Report of the Interim Director of Planning, Regeneration & Public Realm

Address WATERDELL FARM SPRINGWELL LANE HAREFIELD

Development: Conversion of 2 no. agricultural barns at Waterdell Farm to 5 no. dwellinghouses (Class C3), with associated building operations including installation of new windows, doors, rooflights, re-roofing and external cladding (Application for Prior Approval under Schedule 2, Part 3, Class Q of the Town and Country Planning (General Permitted Development) (England) Order 2015 (as amended)).

LBH Ref Nos: 39606/APP/2022/2435

| Project<br><b>787 - Waterdell Farm</b> |       |         | Dwg Title<br><b>Proposed Site Plan</b> |               |       |

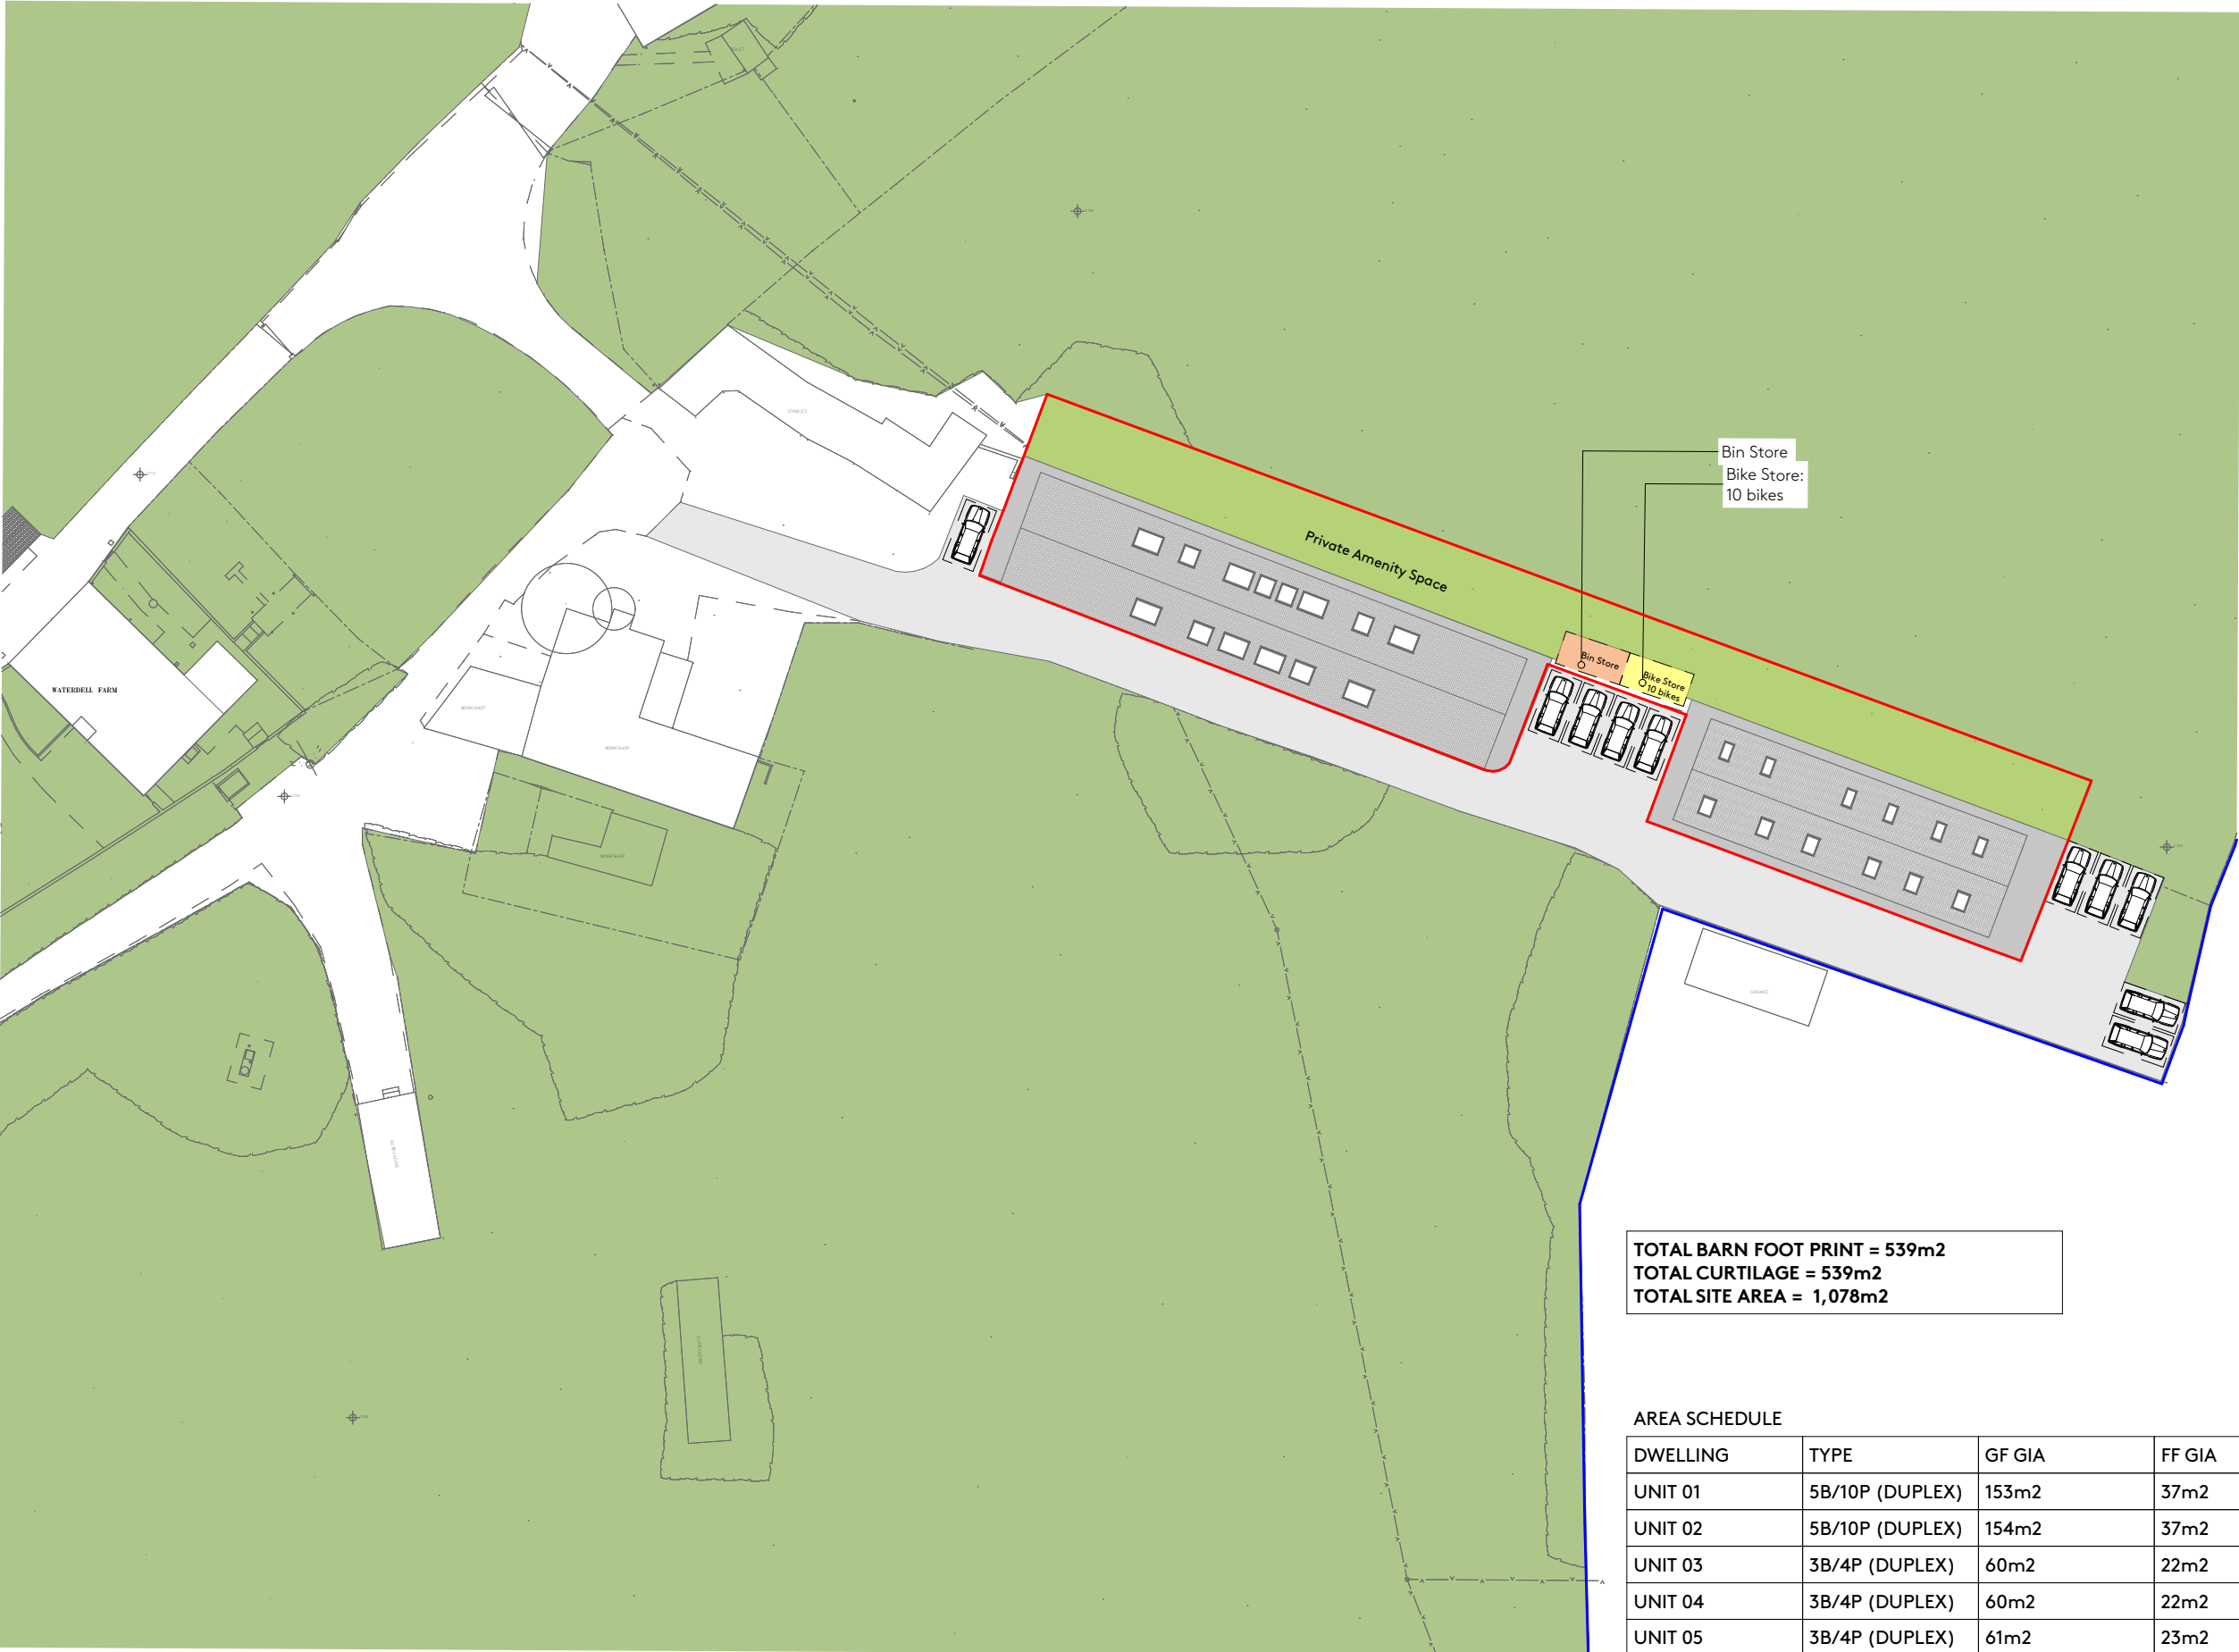
Planning Officer Comment: It should be noted that the access road leading to the application buildings and 6 of the proposed on-site car parking spaces do not form part of the site curtilage (i.e. the red line boundary). This has a material impact on transport and highways, and the full impact cannot be assessed.

Refuse collection would occur from Springwell Lane and bin storage positioning should conform with accepted 'waste distance' collection standards which encourage waste collection distances to be within 10m from the point of collection on the roadway. As the proposal site is set centrally and deep within the main farm envelopment, far in excess of the said distance parameter, this aspect requires resolution.

- For this scale of development, it is likely to be in the best interest of the new occupiers to place their refuse within the 10m distance parameter if they wish for their refuse to be collected. However, the 'drag' distance from the barn redevelopment area to the highway (Springwell Lane) is up to 200m hence this may not be a practical option.
- Alternatively, a smaller refuse vehicle may need to enter the site envelope to execute waste pick-up. This exercise would aim to demonstrate that all service/refuse vehicles entering the site can perform their function and be satisfactorily accommodated without detriment to the internal site workings. The importance of this aspect is particularly vital given the Green Belt status of the site envelope.
